CITY OF ALBUQUERQUE

August 31, 2023

Re: Jefferson Hotel
5910 Jefferson St. NE
Traffic Circulation Layout
Architect's Stamp 07-28-23 (E17-D011C)

TCL-1
7/28/23

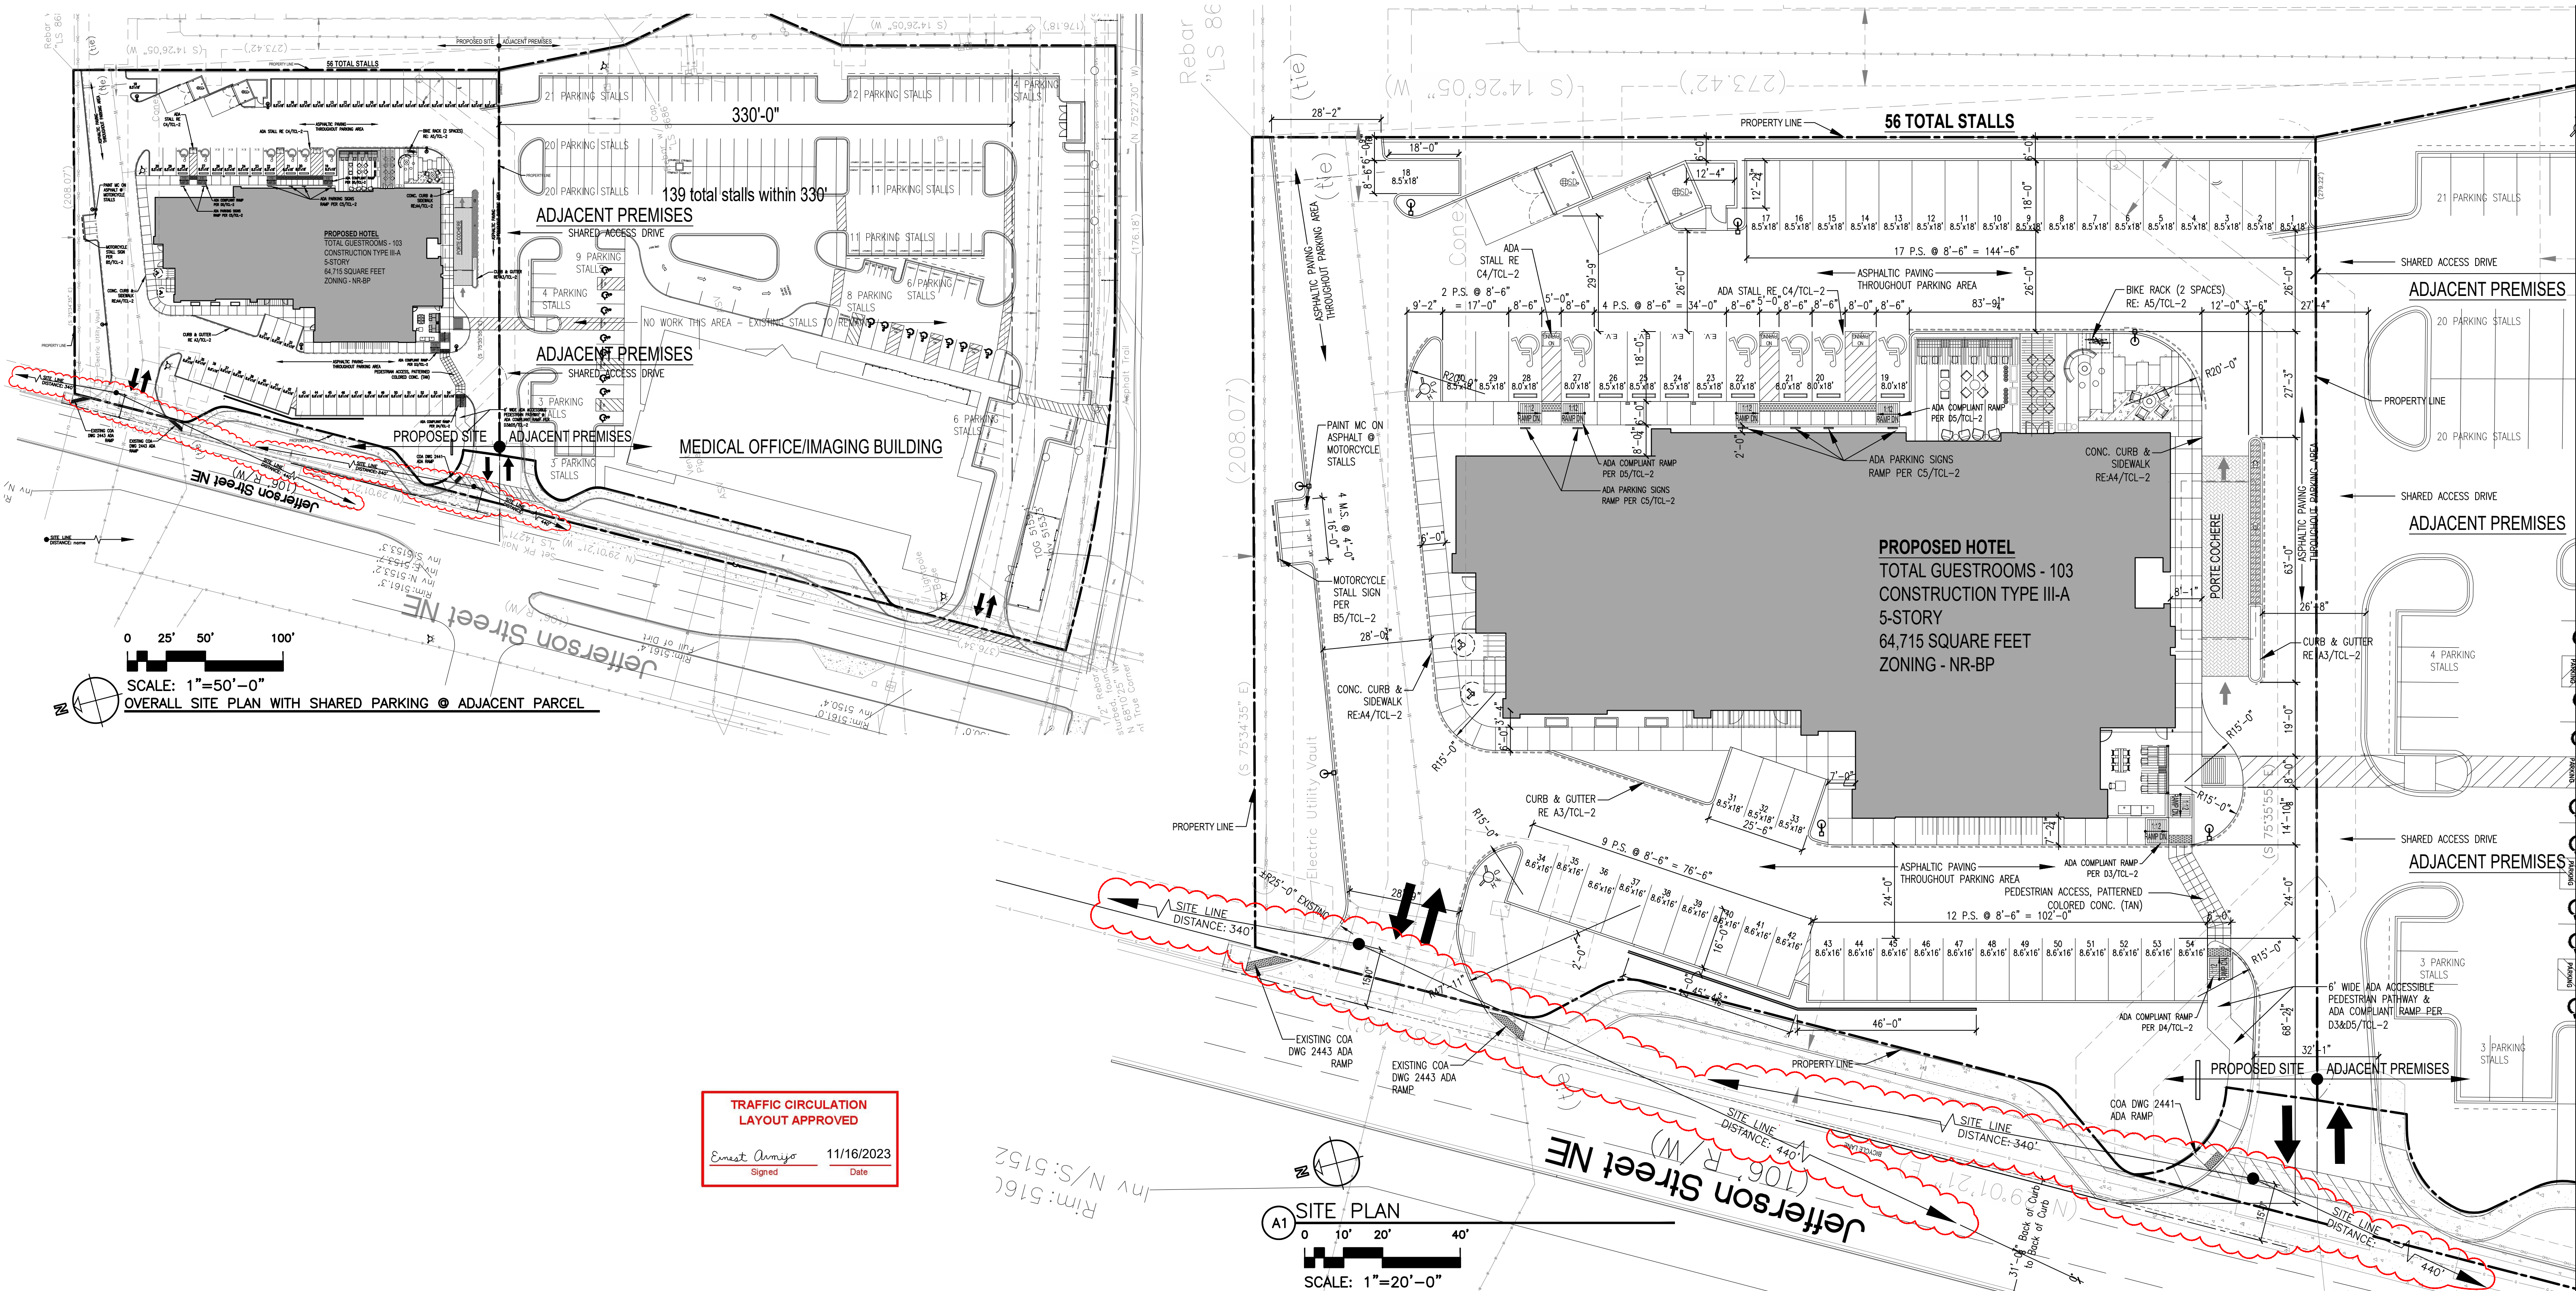
1. Please revise the parking requirements table. There needs to be more parking spaces to share with adjacent south property. See the attached approved adjacent property site plan.
2. Please clarify, why there are two property line on the site plan?

3. Show the Intersection clear sight triangle on the site plan for the south site access.
4. Show the clear sight triangle on the site plan for the north site access.
5. Traffic Studies: See the Traffic Impact Study (TIS) thresholds. In general, a minimum combination of 100 vehicles entering and exiting in the peak hour warrants a Traffic Impact Study. Visit with Traffic Engineer for determination, and fill out a TIS Form that states whether one is warranted. In some cases, a trip generation may be requested for determination (**Contact Matt Grush: mgrush@cabq.gov**).
6. Please provide a letter of response for all comments given.
